DELEGATED HOUSEHOLDER DECISION

Item No.	Report of the Head of Development Management and Building Control		
Address:	3 ACACIA AVENUE RUISLIP		
Development:	Construction of a part single-storey, part two-storey wraparound extension to the side and rear following the demolition of the existing garage		
LBH Ref Nos:	43839/APP/2024/3274		
Drawing Nos:	Existing Elevations & Floor Plans 201 B 202 B 300 400		
Date Plans received:	16-12-24	Date(s) of Amendments(s):	22-01-25
Date Application valid	16-12-24		22-01-25 22-01-25

Notes:
All dimensions should be checked with a site survey.
Drawings are subject to statutory authority approval and are to be used for the purpose of planning.
Structural calculations and drawings to be supplied by a structural engineer.

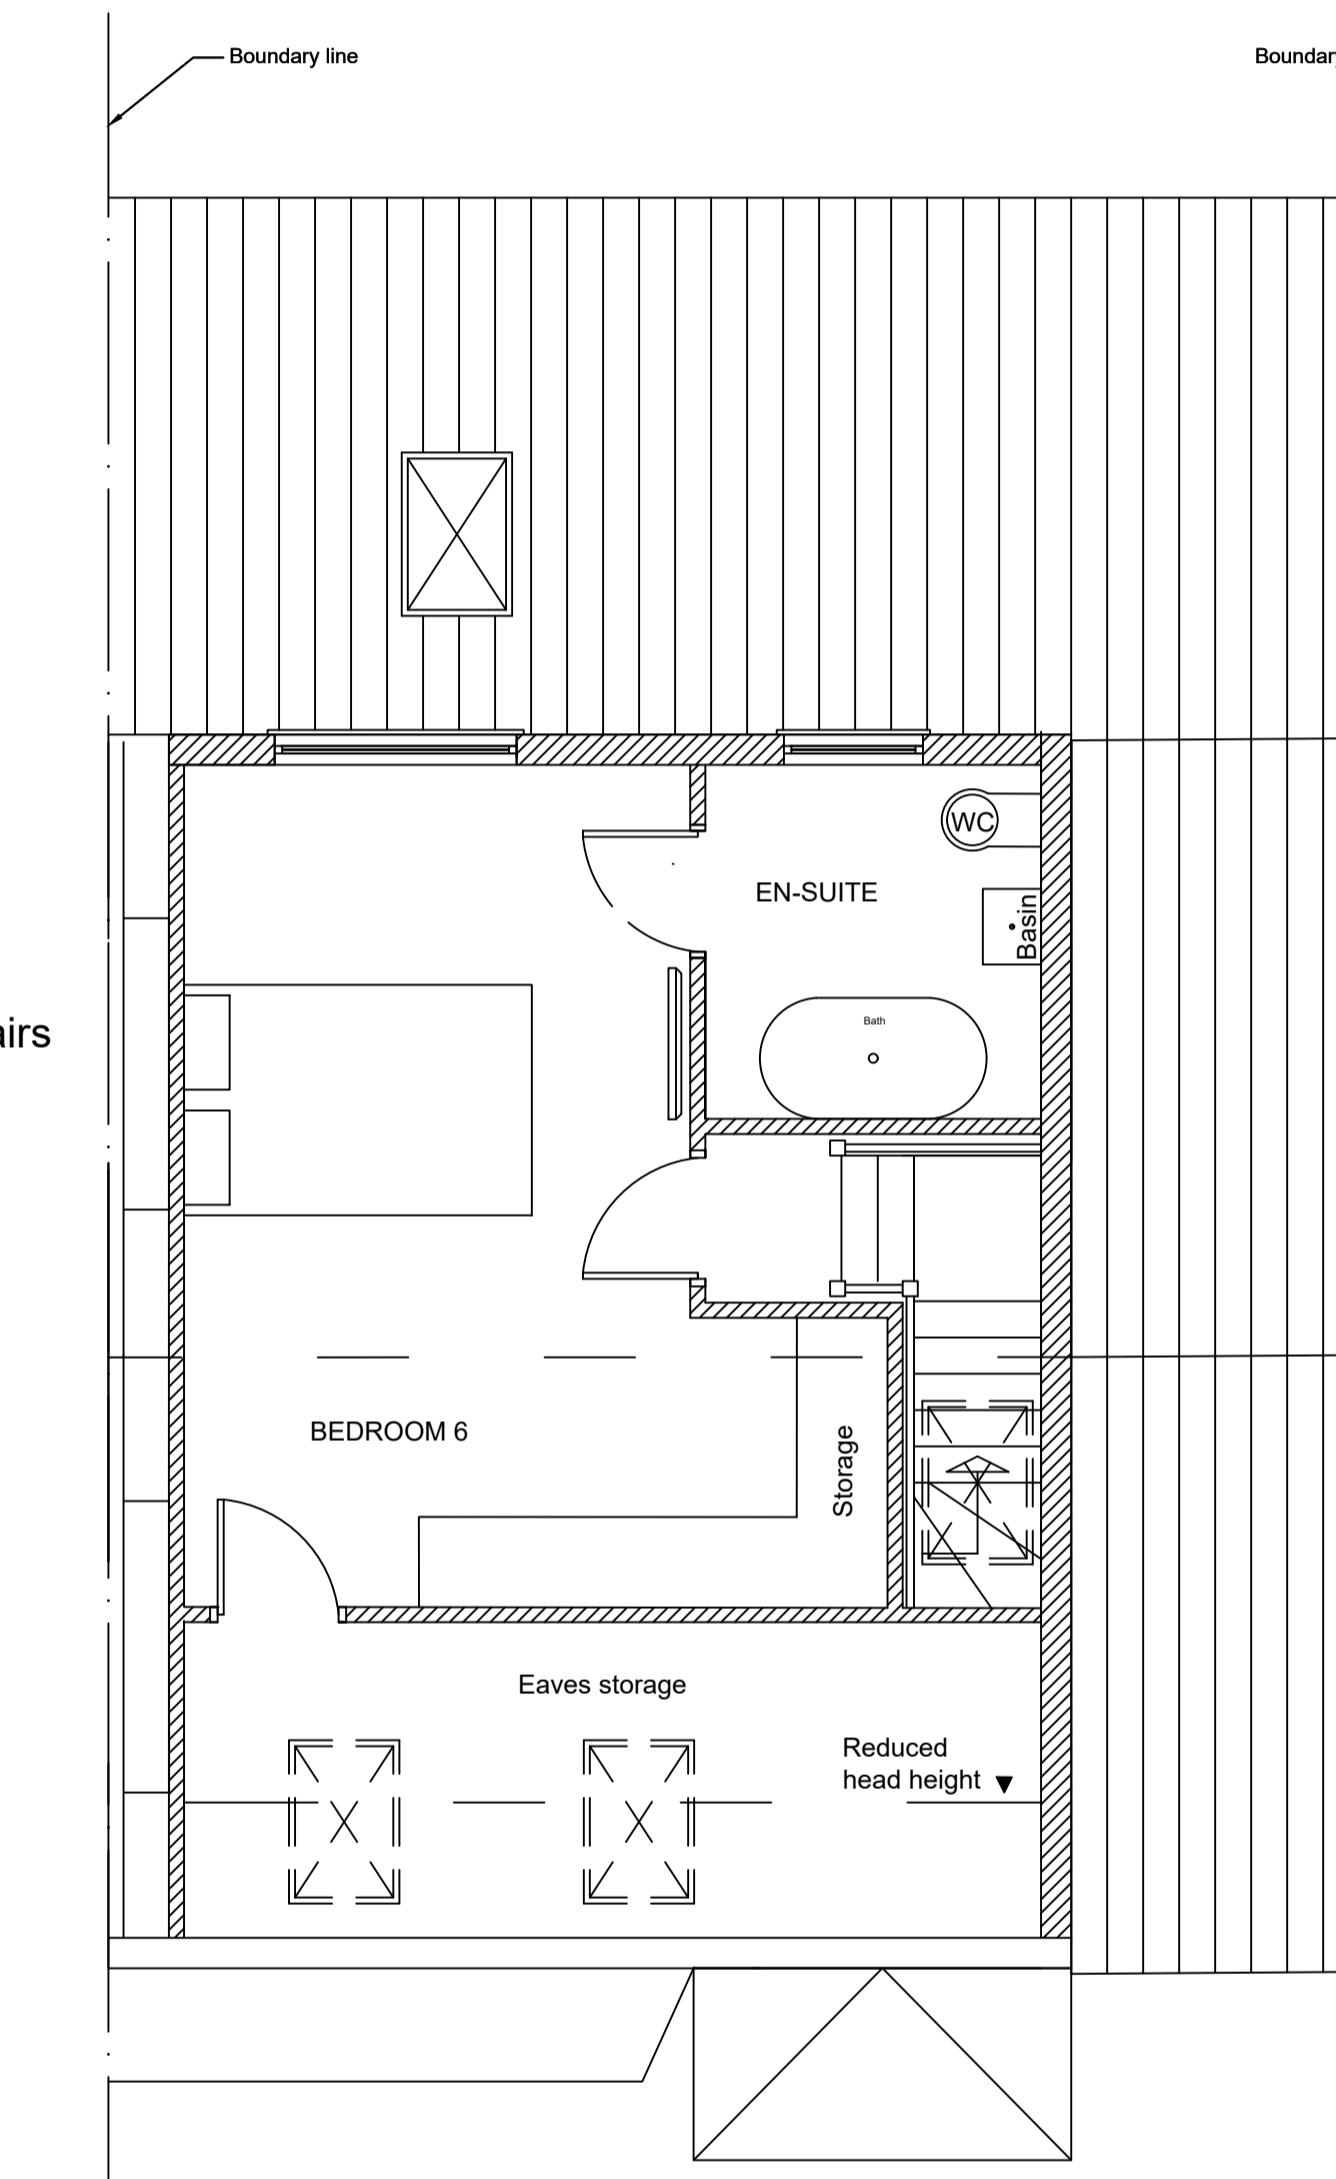
The two-storey side extension was originally proposed to be constructed on the side boundary; however, after receiving feedback from the local authority, the applicant submitted an amended scheme with the extension set in 1m from the side boundary in accordance with Policy DMHD 1. The extension would, therefore, be less than half the width of the original property and set back 1m from the side boundary. This would ensure the extension would be in proportion with the existing dwelling and maintain a good separation from the neighbouring property, avoiding any adverse impacts on the streetscape character. The extension would be set back 700mm from the front projecting bay window, but in this instance, the setback is considered acceptable as it would still be subordinate to the bay window feature and would create a consistent frontage with the existing setback entrance. The extension has been designed with a lower roof profile than the original dwelling, ensuring it would be subordinate to the original dwelling.

The proposed side extension would be visible to 5 Acacia Avenue, but the amended proposal includes a setback of 1m from the shared side boundary in compliance with Policy DMHD 1, addressing previous concerns over dominance and loss of daylight to the neighbour. The two-storey extension would not extend past the existing rear building line of the application site, which is approximately the same as that of 5 Acacia Avenue, and as a result, would not intrude into the 45-degree line of sight from the rear windows of the neighbour, ensuring it would not be overly dominant or bulky. Given the 1m setback and the fact that the application property is located slightly north of 5 Acacia Avenue, no undue harm would befall the daylight and sunlight access of the neighbouring dwelling. The proposed single-storey rear complies with Policy DMHD 1 with respect to the height and depth of the extension and would be set back 1m from the shared boundary. As a result, the extension would not be overly dominant or bulky to the neighbouring occupiers, nor would it unduly impact daylight & sunlight access to the neighbouring property.

The application removes an existing first-floor flank window facing 5 Acacia Avenue. A new flank window is proposed at ground level facing 5 Acacia Avenue; however, this is proposed to be obscure-glazed, would not serve a habitable room (only a bathroom), and the outlook from the window could be readily blocked by boundary fencing. As such, the application reduces overlooking 5 Acacia Avenue and would not unduly harm their privacy. A condition is attached, requiring the flank window to be obscurely glazed. As such, with the inclusion of appropriate conditions, there would be no undue harm to the daylight, privacy, outlook, or other amenities of 5 Acacia Avenue caused by the proposal.
